Please ask for: Jonny Cooper
Email: jonny.cooper@arun.gov.uk
Telephone: 01903 737532
Our Ref: FG/14/25/PL
Your Ref:
Date: 29th January 2025

Application for Planning Permission

Development: Partial removal of rear extension of 275 Goring Way and erection of 1 No. self-build chalet bungalow in garden of 275 Goring Way with associated landscaping and parking. This application is in CIL zone 4 and is CIL liable.
Location: 275 Goring Way Ferring BN12 5BY

A :: Existing South Elevation
01 scale: 1:100

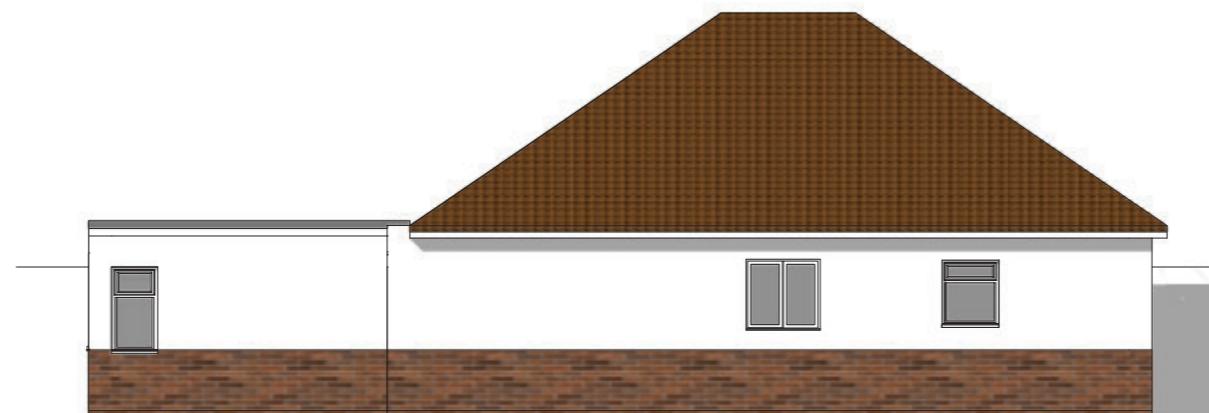
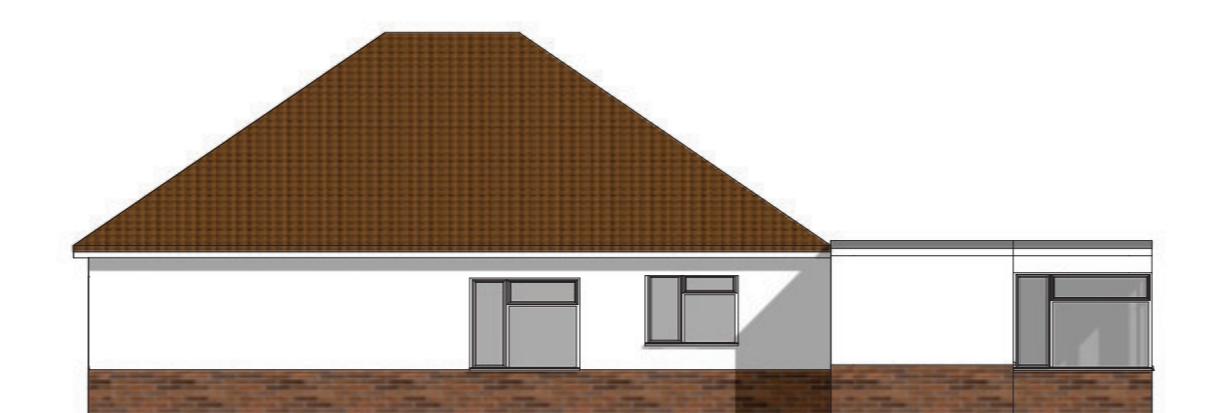
The door serving the porch on the existing ground floor plan should be viewable on the existing south elevation, but is not. Please amend these and resubmit the plans.
